**DELEGATED DECISION TO DETERMINE PLANNING APPLICATIONS**

**Reference No:** 2019/62/90141/W

**Site Address:** High Beeches, 585, Manchester Road, Linthwaite,  
Huddersfield, HD7 5QX

**Description:** Erection of single storey extensions and conversion of  
loft space with rear dormer and alterations to front  
gable.

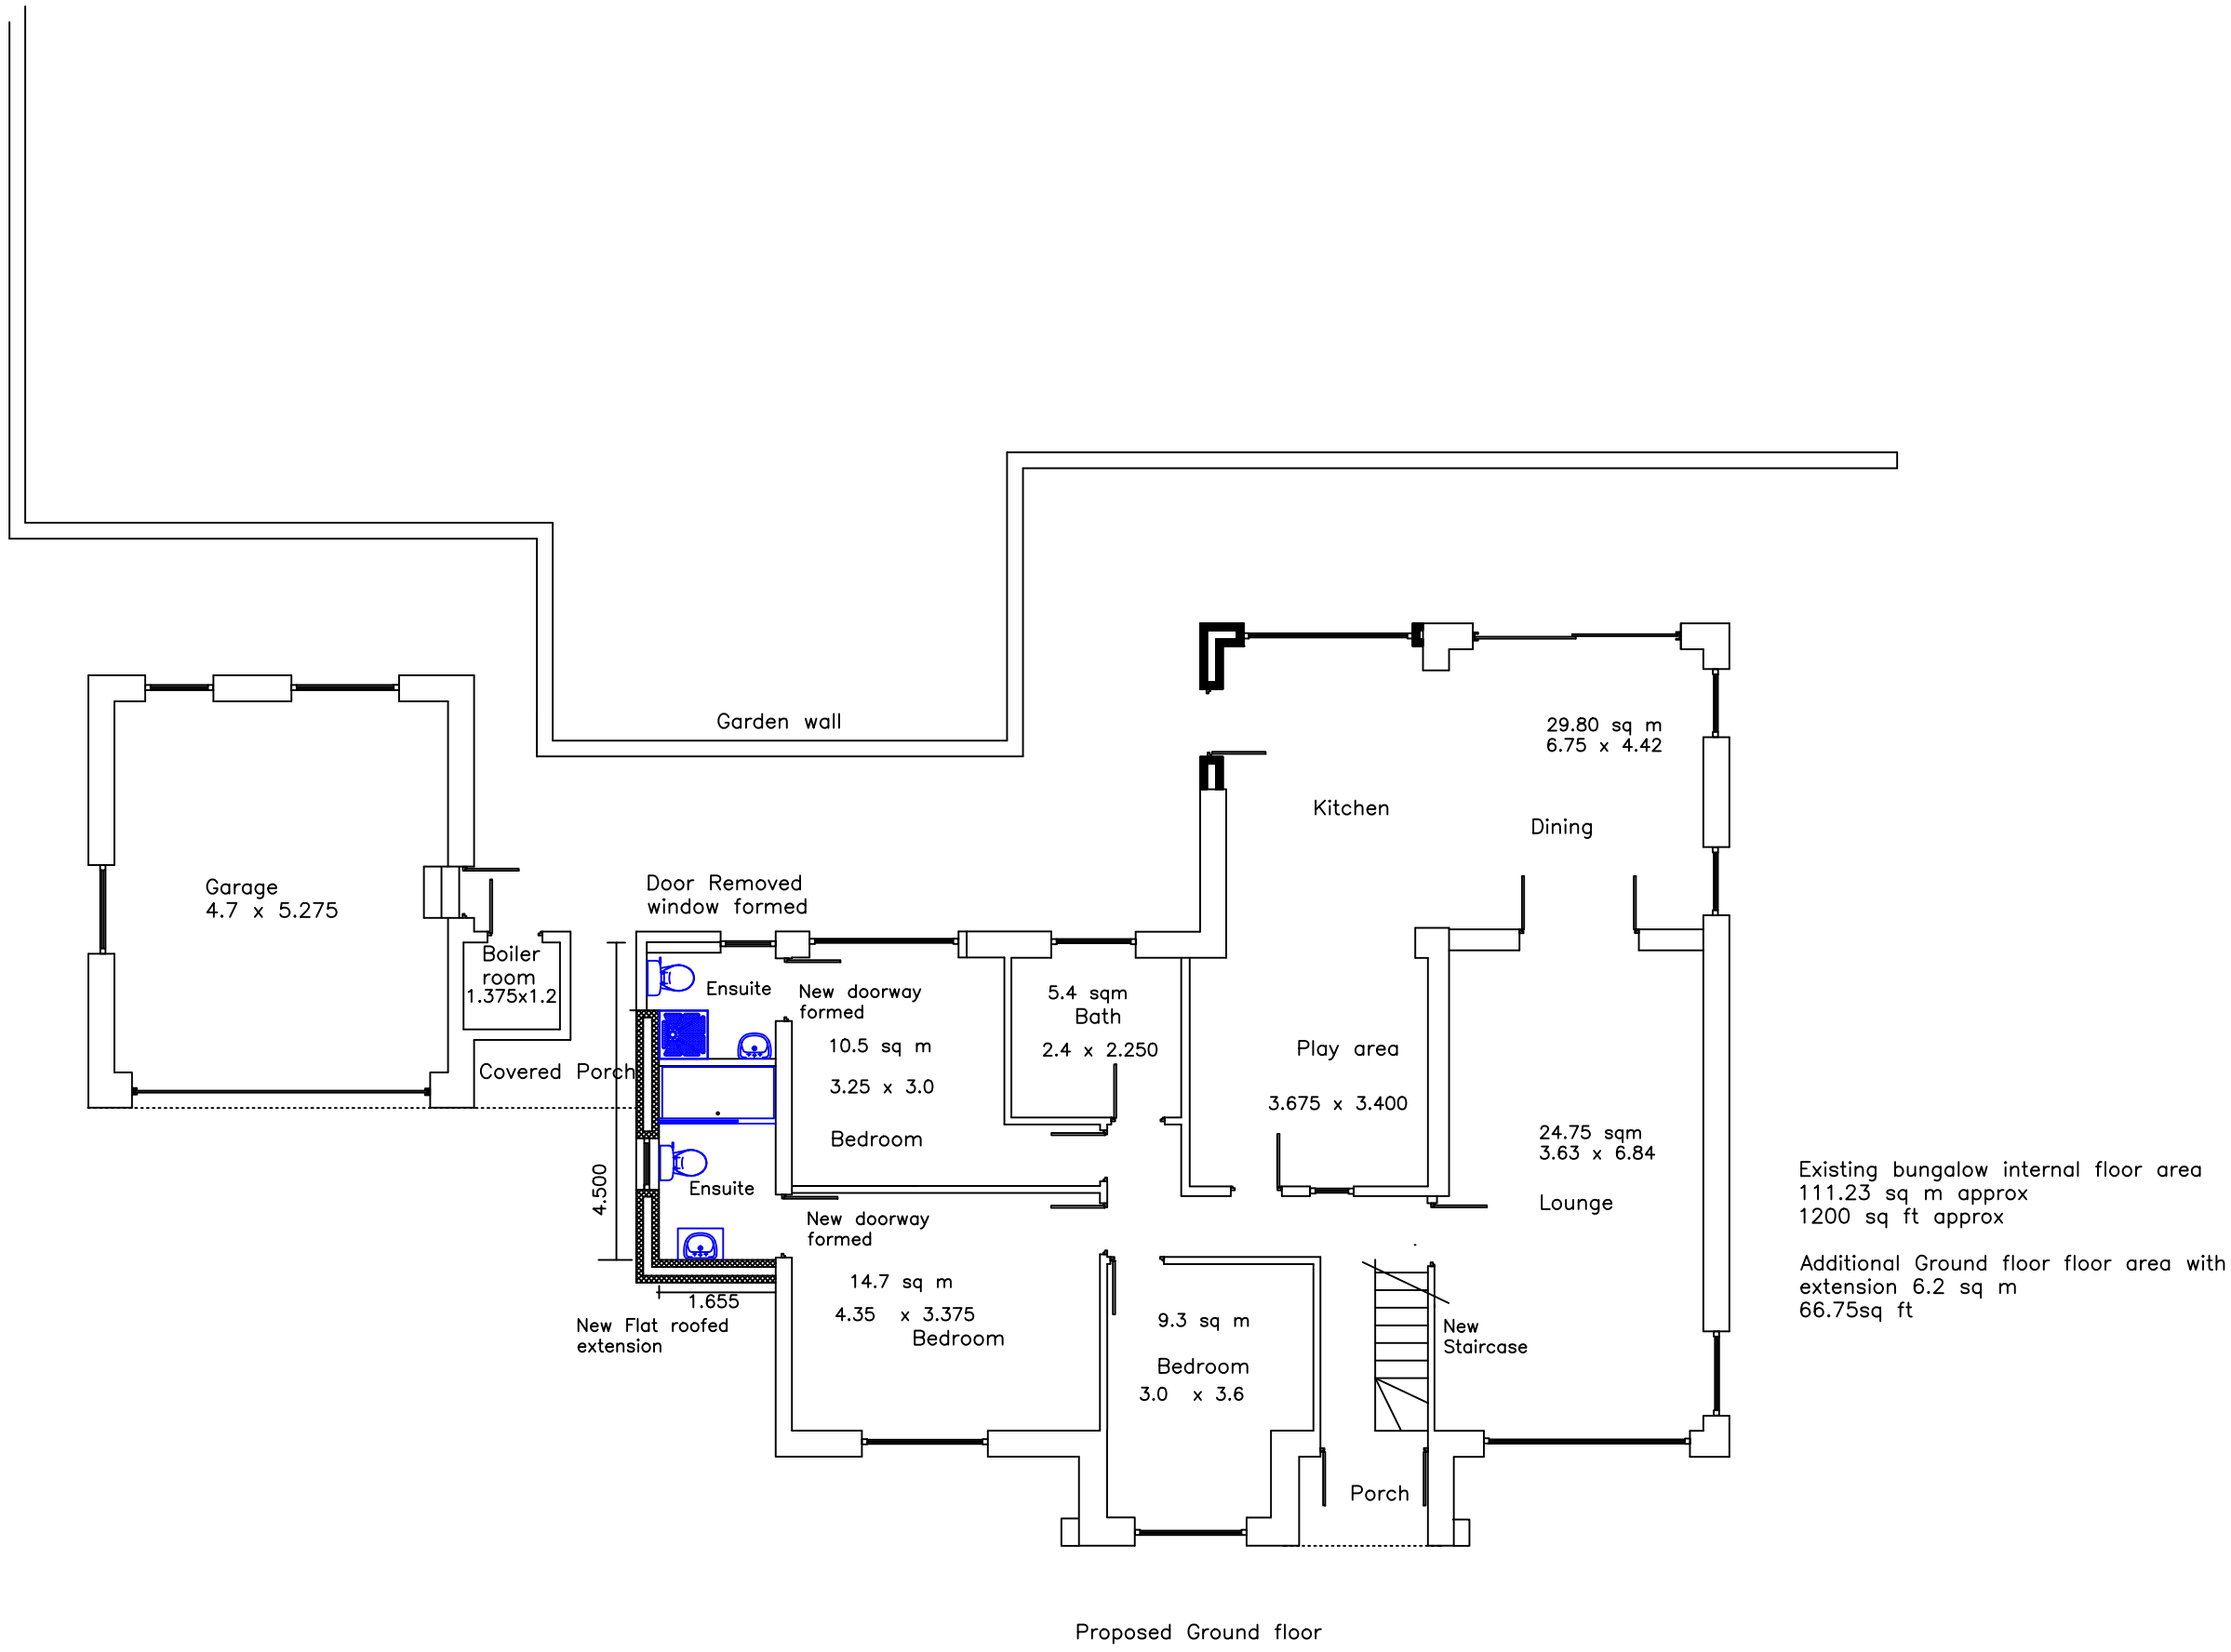
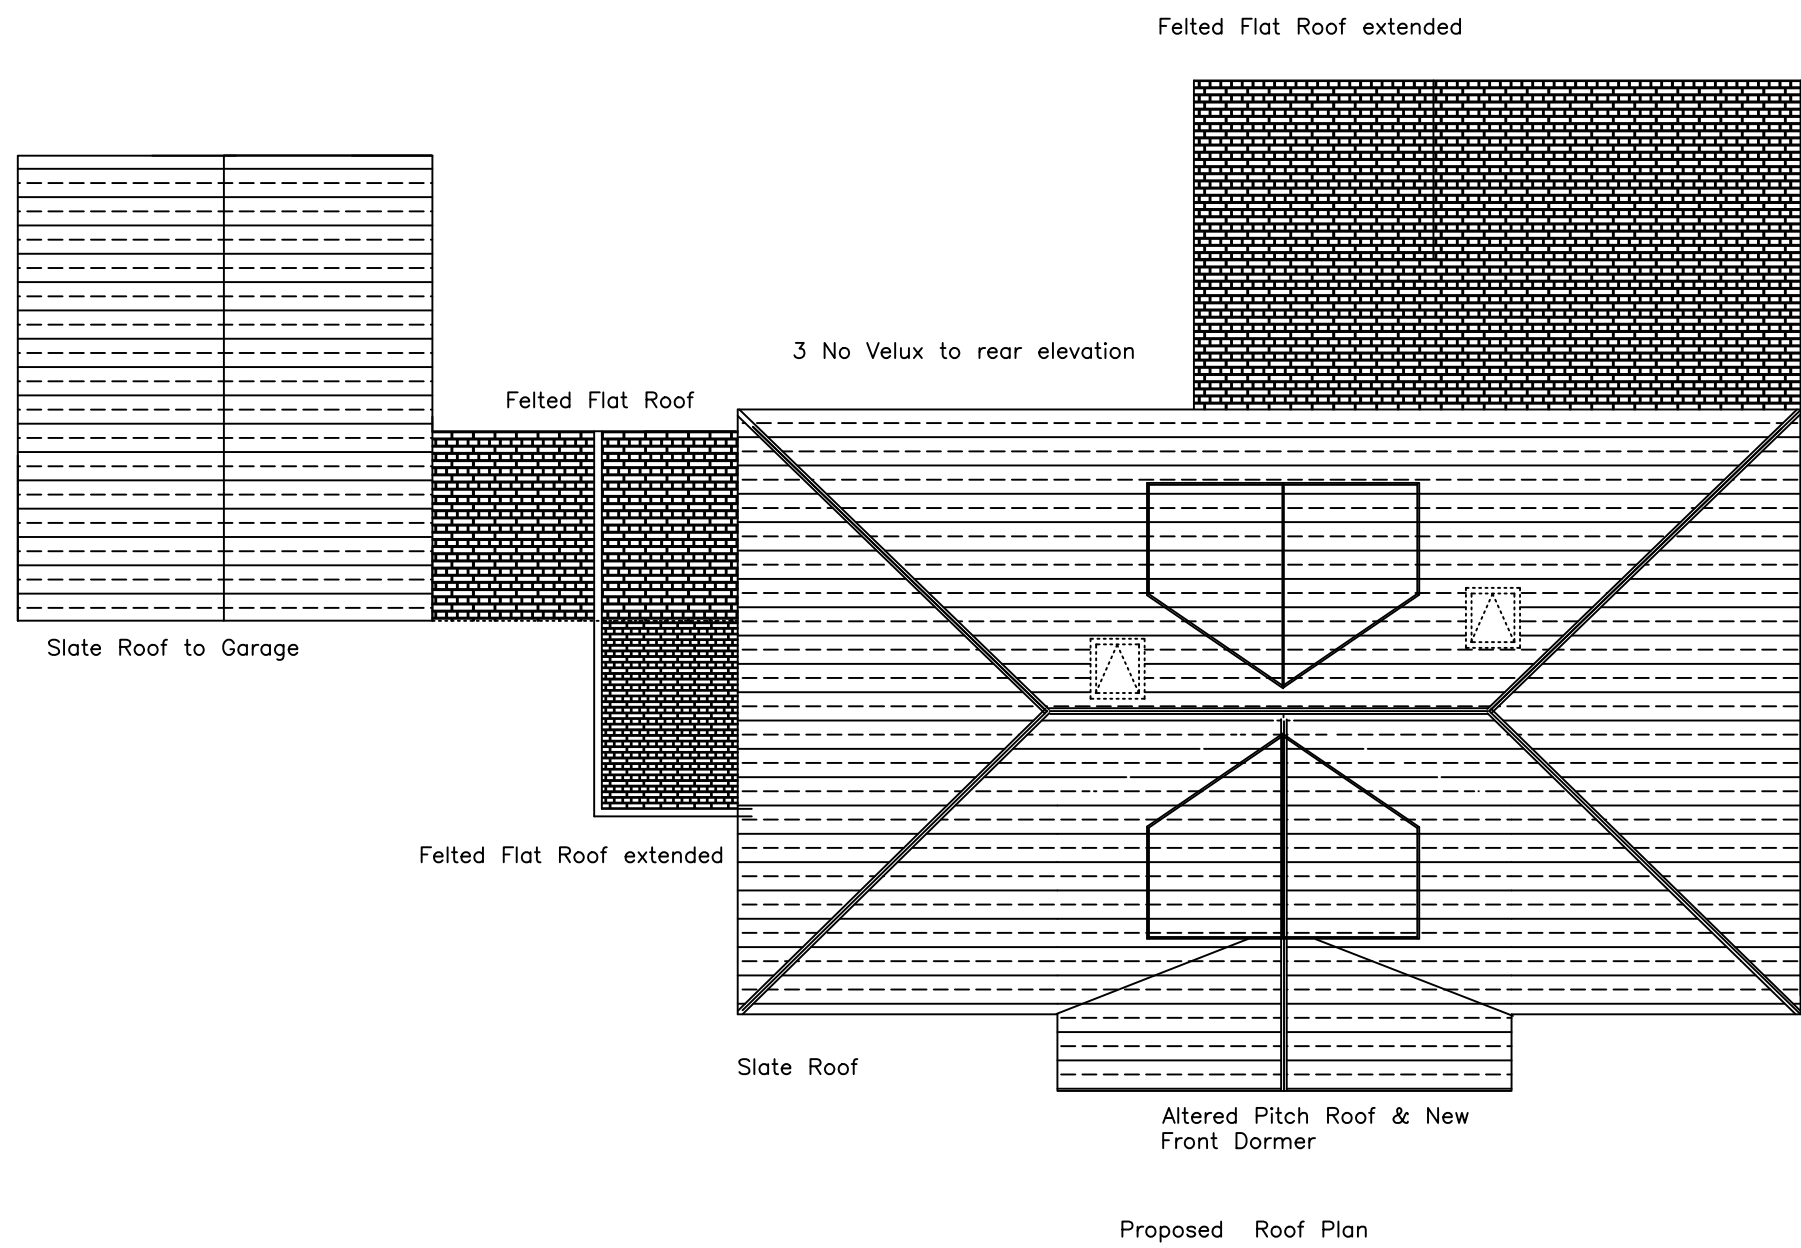
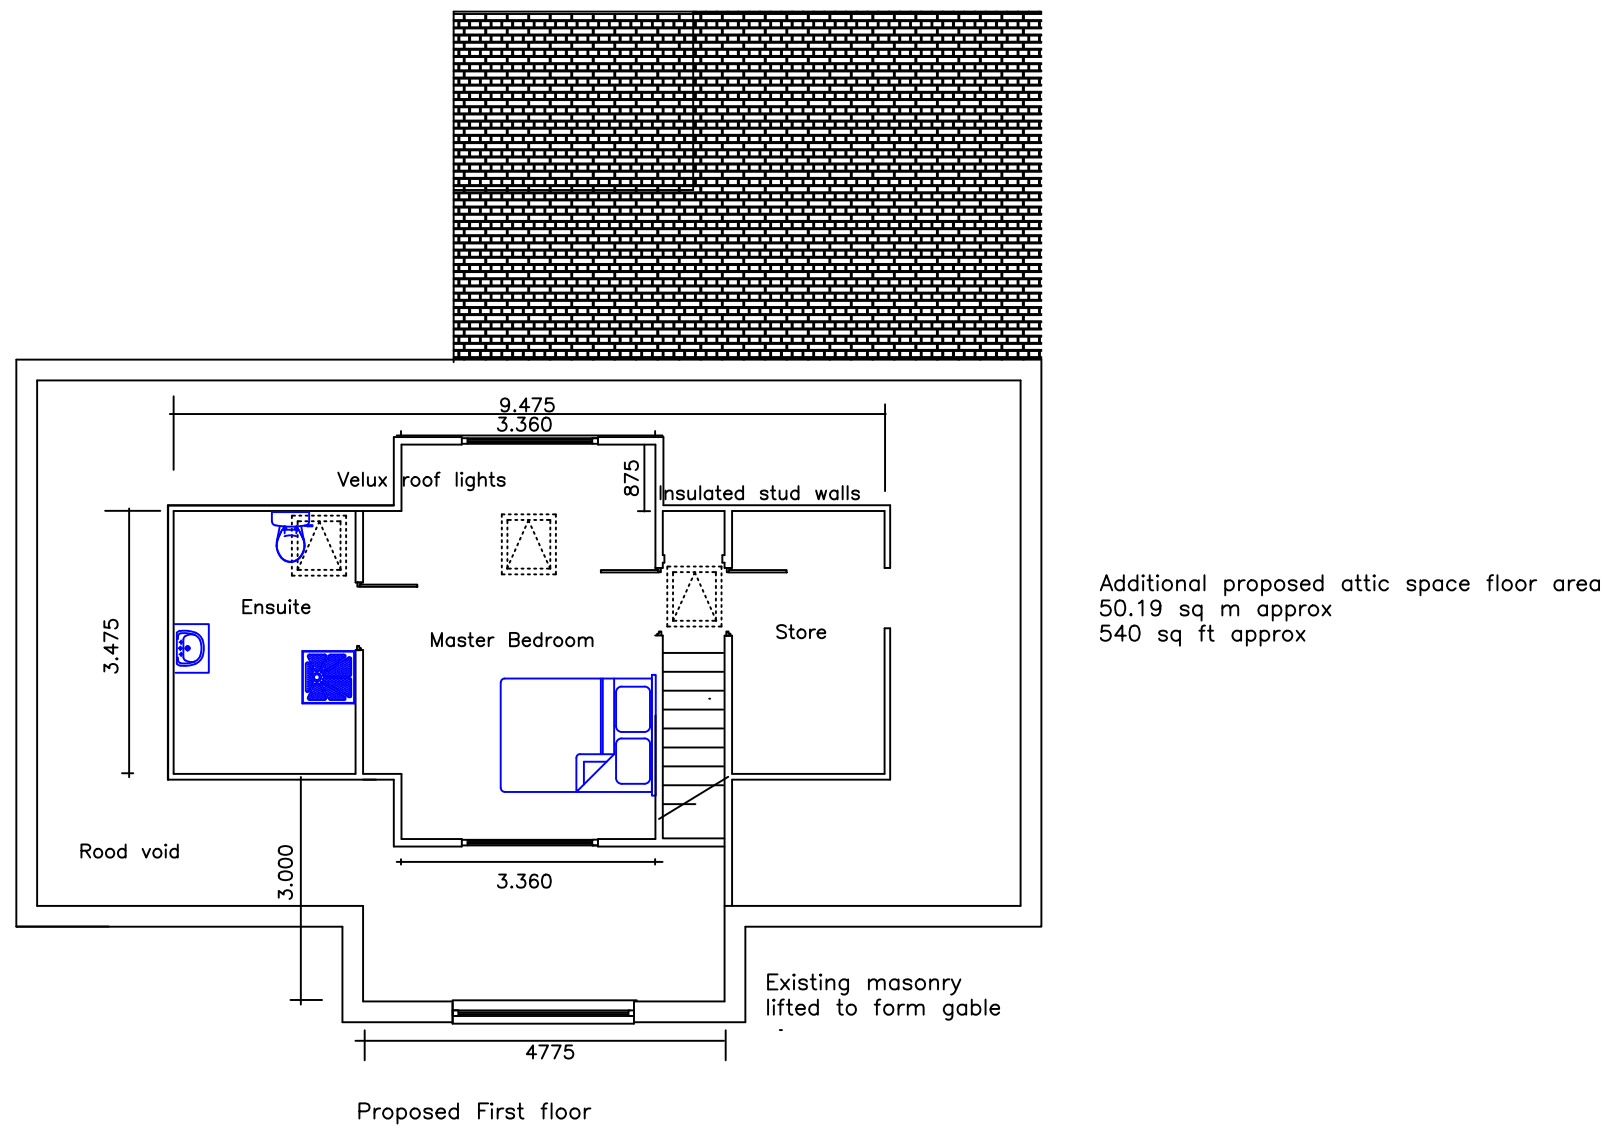
It was originally proposed that the eaves of the front gable would be raised however following concerns raised following the site visit, the eaves were reduced back to as existing with the roof pitch of the gable reduced and a dormer extension proposed above the gabled feature. The width of the dormer would be 3.6 metres with the eaves height being 0.9 metres with an overall height of 1.7 metres to the ridge of the pitched roof. The dormer would be finished with vertical hung slates to the face and cheeks with the extension allowing accommodation to be located within the roof slope.

Following the site visit, concerns were raised regarding the raising of the eaves height of the front gable and it was suggested to the applicant that this feature be removed and replaced with a front elevation dormer extension. This amendment was made and amended plans were received on 7<sup>th</sup> February 2019. As the scheme had been reduced, it was not considered necessary to re-advertise the proposal.

The dormer extensions would be located within both the front and rear elevations of the property and would be centrally placed. To enable the front elevation dormer, the pitched roof of the gabled feature would need to be reduced. The dormers are relatively small in scale when viewed against the roof scape. The dormers would be tile hung to match the existing roof and the roofs would be slate which would also match.
